RE: Exhibition of State Significant Development Application – Proposed Data Centre Development (SSD-68013714)

**PROPERTY: 43-61 Turner Road, Gregory Hills
Lots 14, 15, 16 and 17 in DP 28024**

Council staff have undertaken a review of the SSDA and supporting information and this letter provides feedback on the proposed development for your consideration.

Drawing Title	ELEVATIONS - SHEET 1																																																						
Drawing Number	SSDA-A-150																																																						
Issue	F

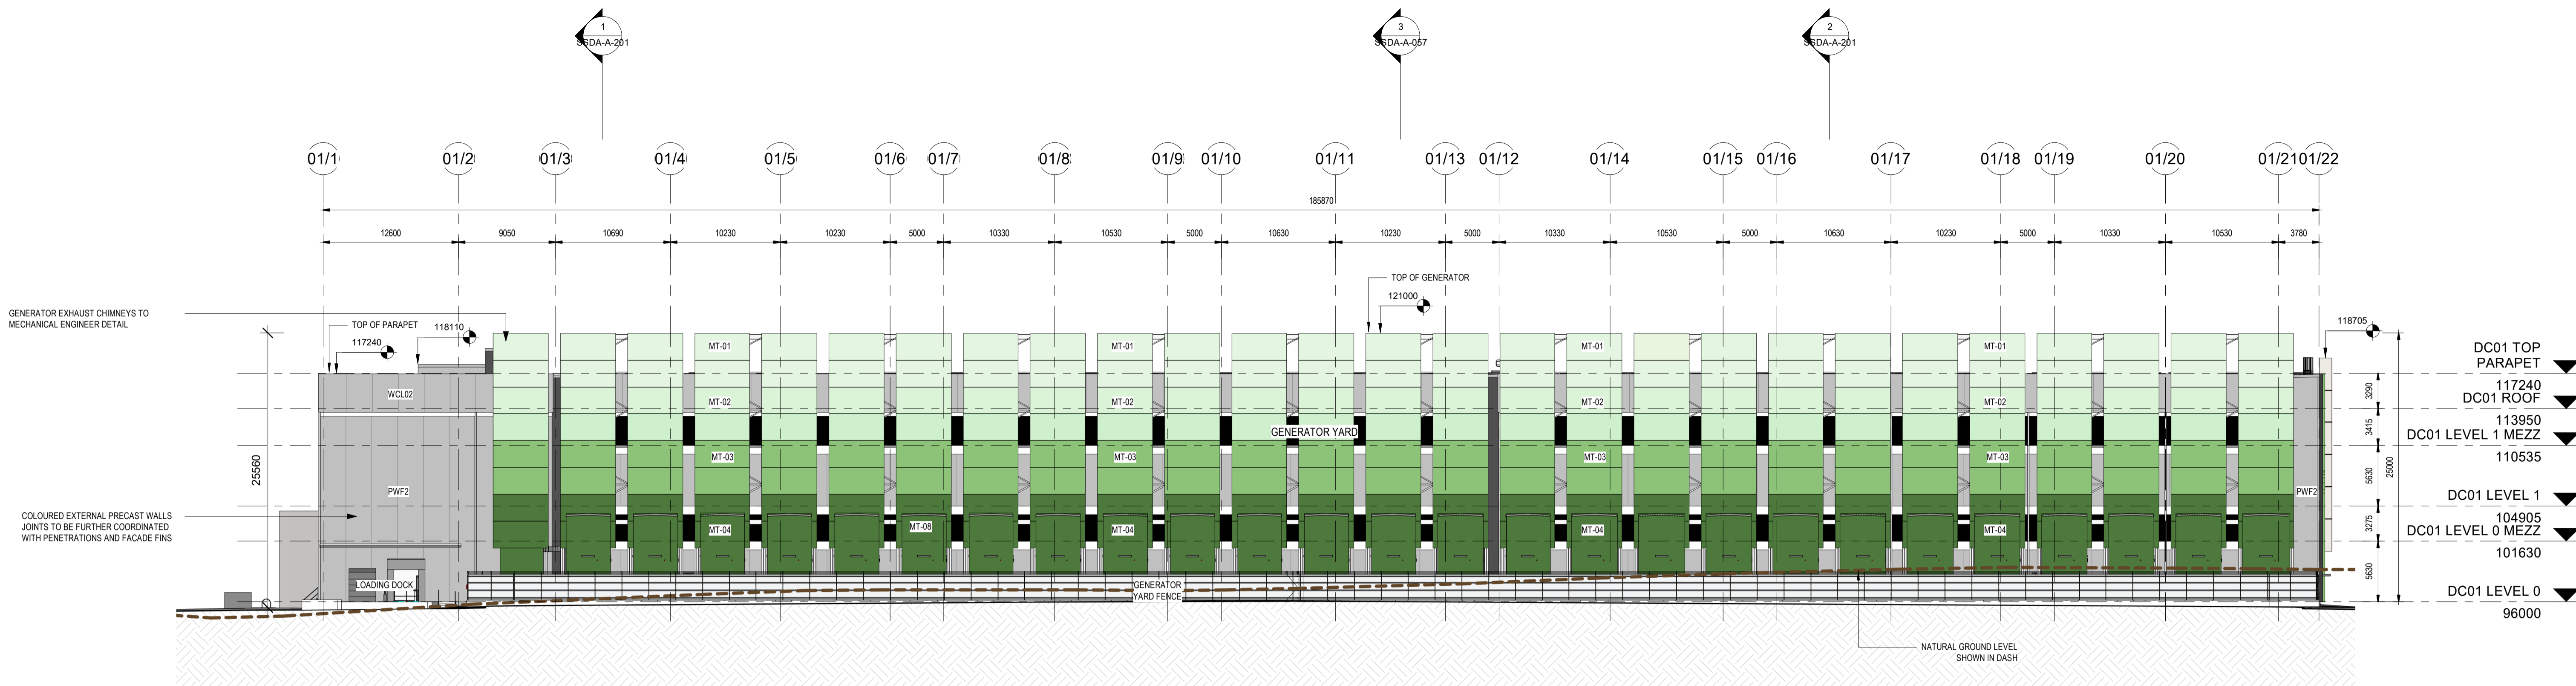
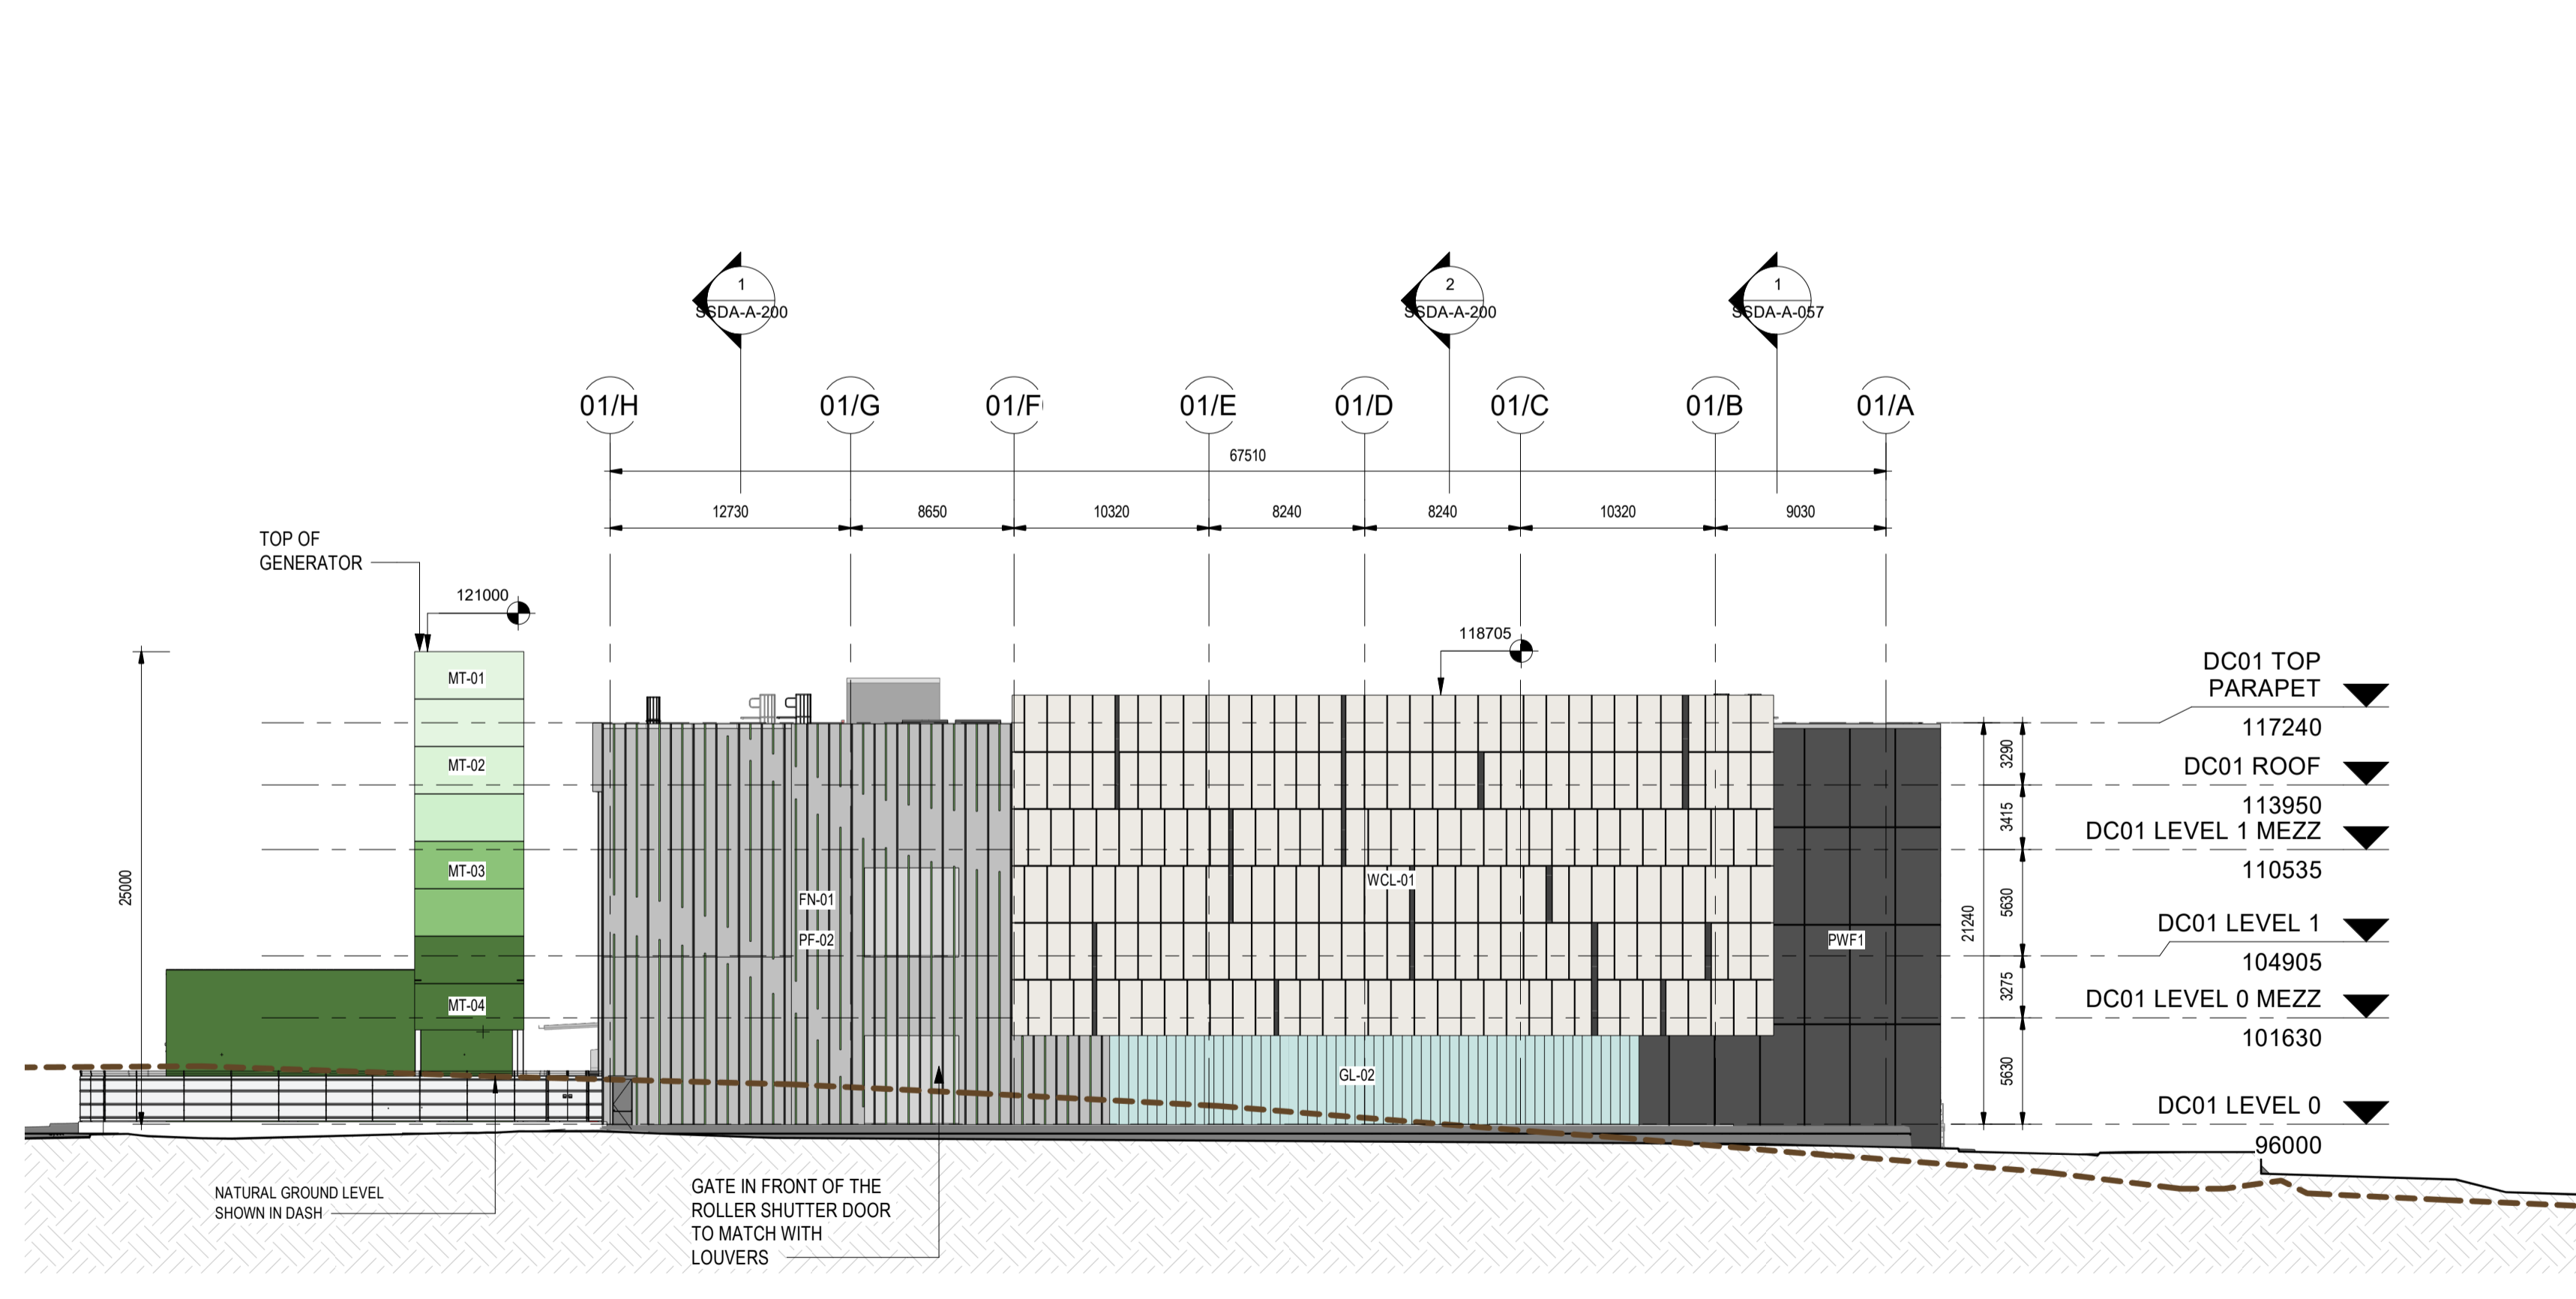
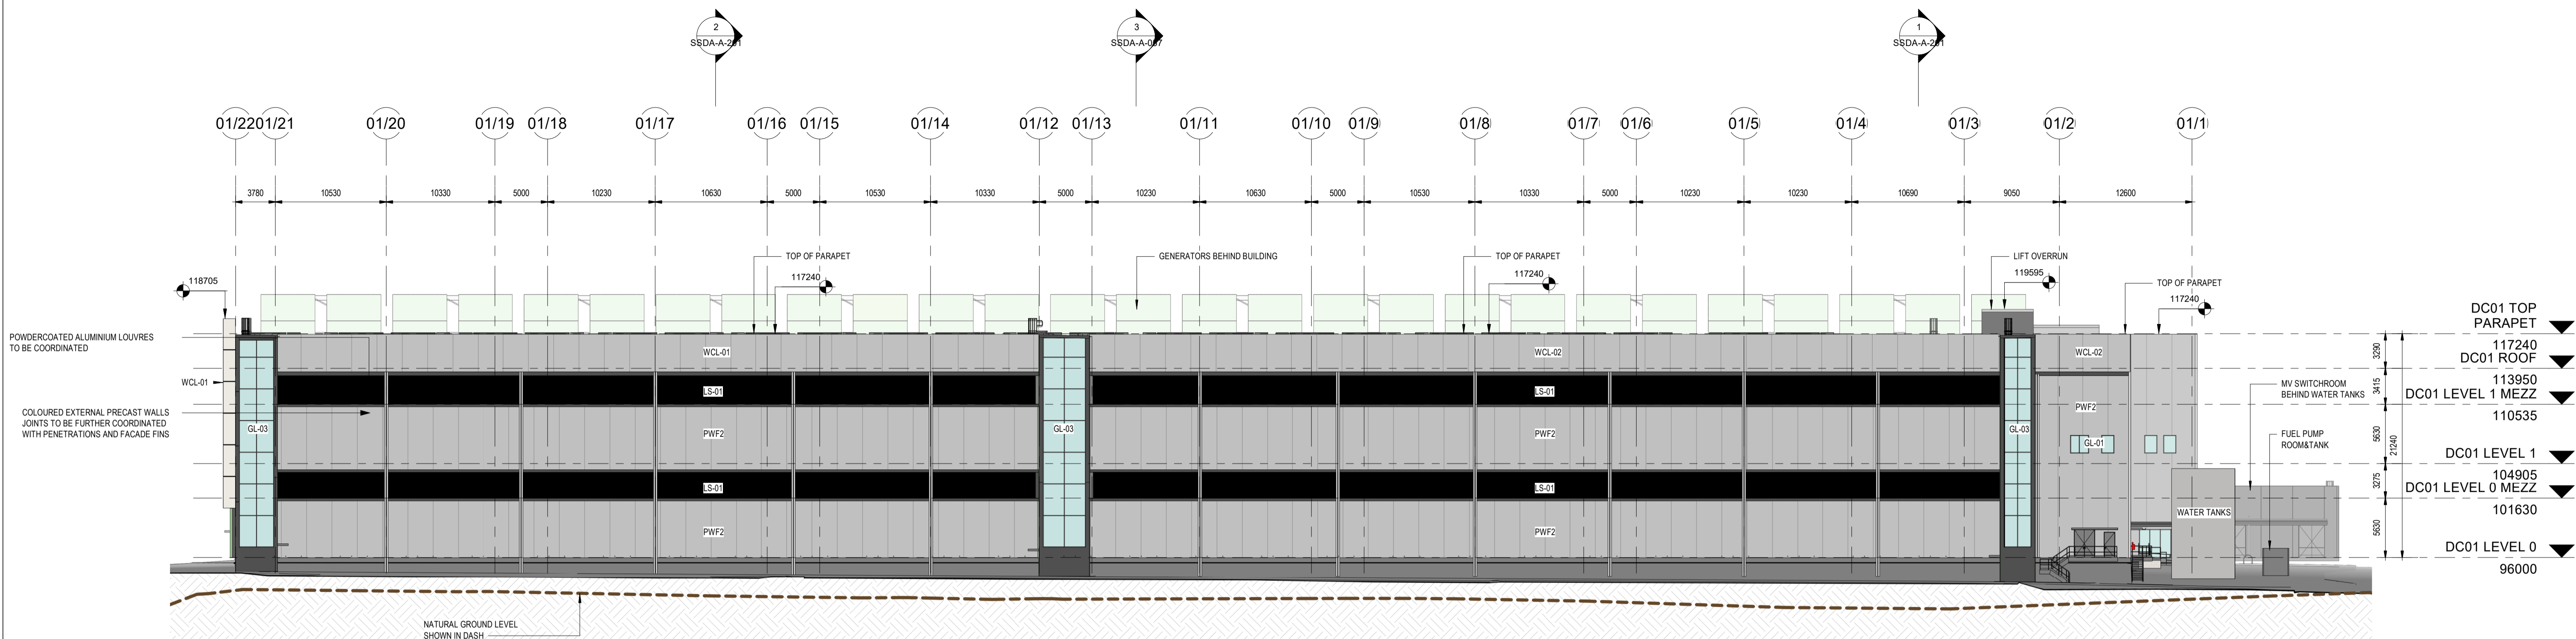
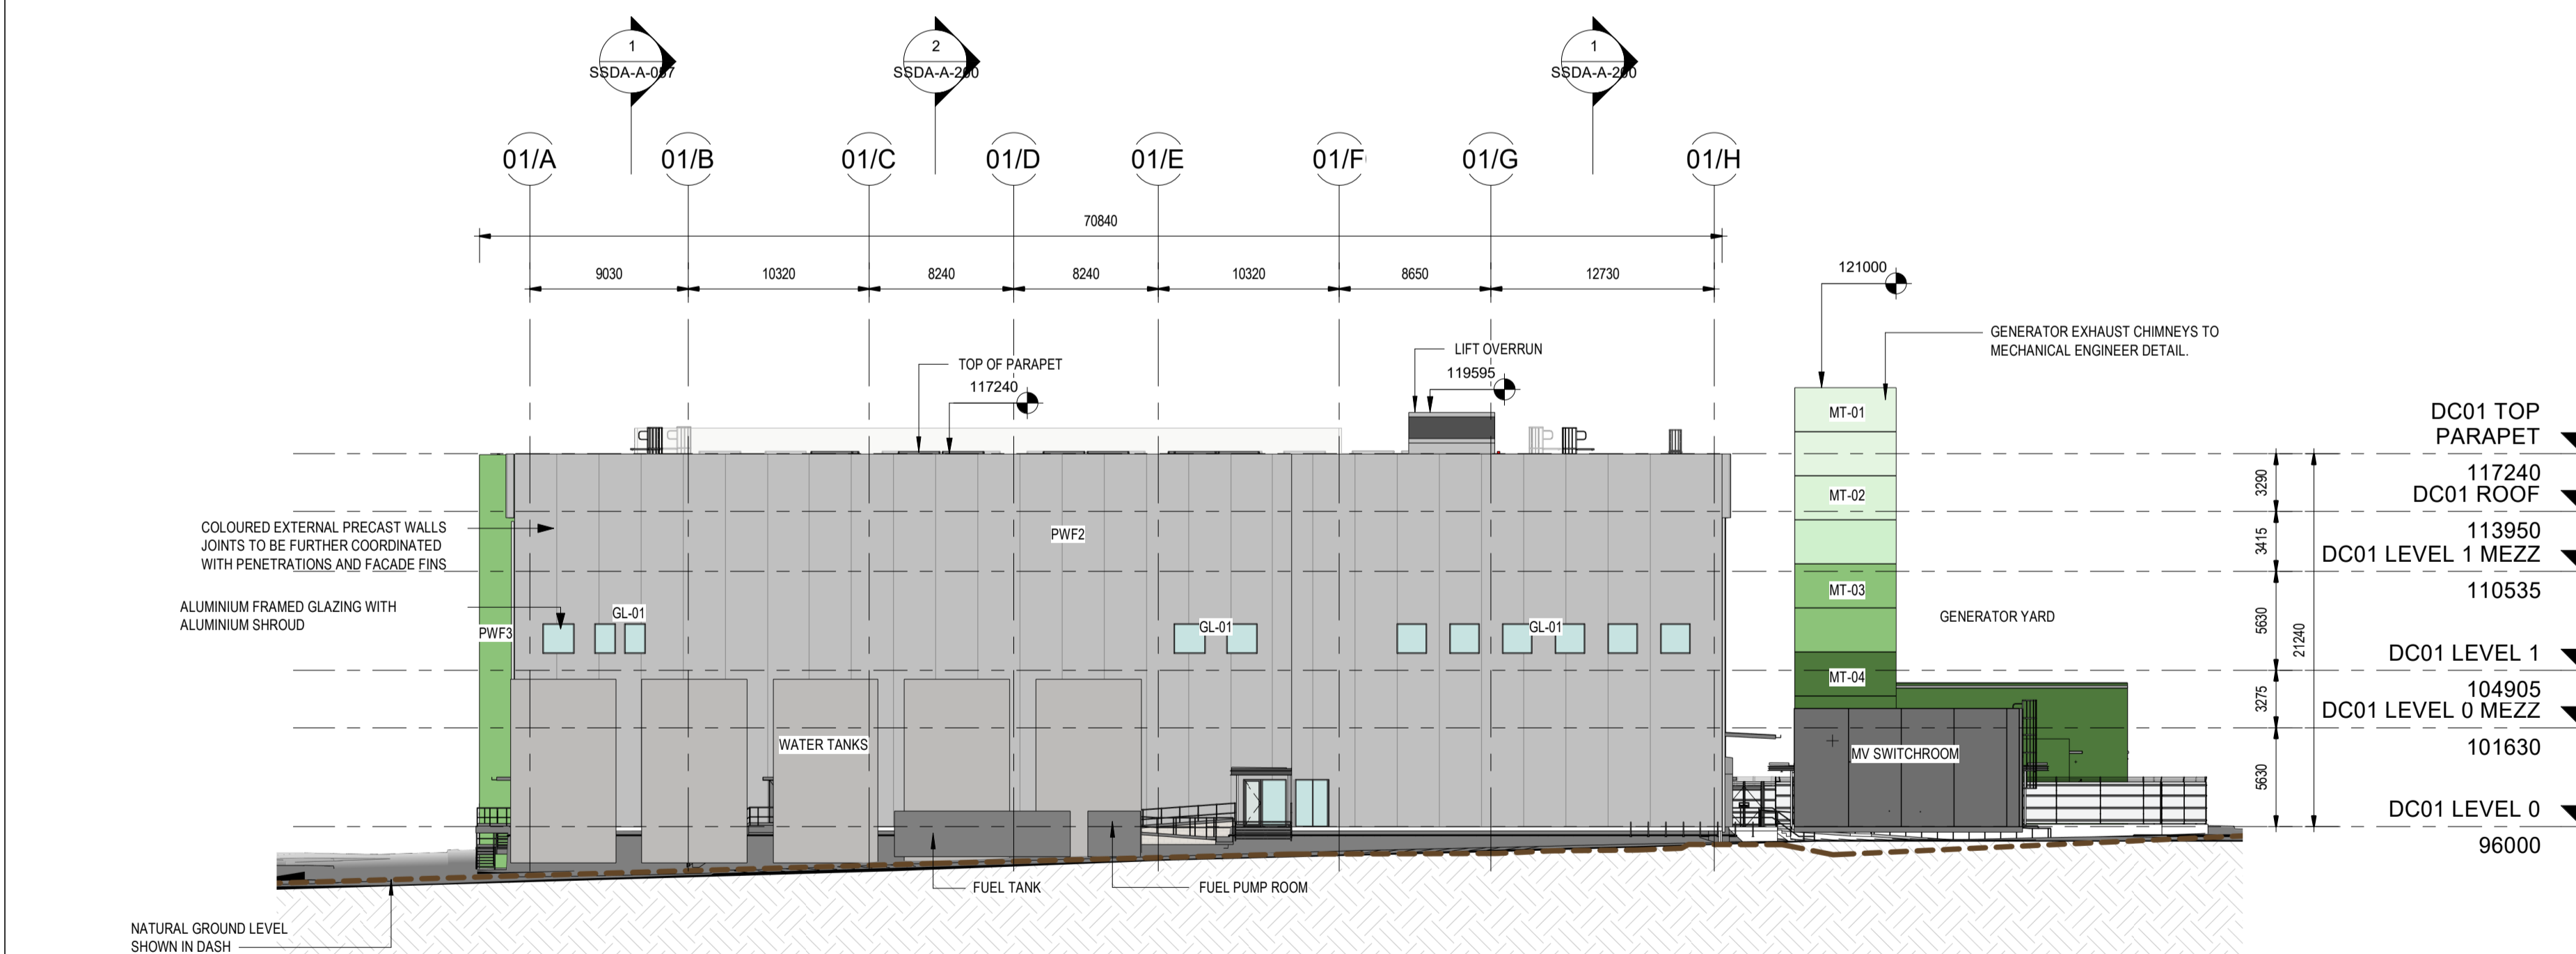
It is noted that the proposed development has a maximum building height of “*approximately 23m*” and thereby contravenes the maximum prescribed building height development standard of 15m. It is considered that the Clause 4.6 written request should accurately identify, and not approximate, the maximum height of the proposed development.
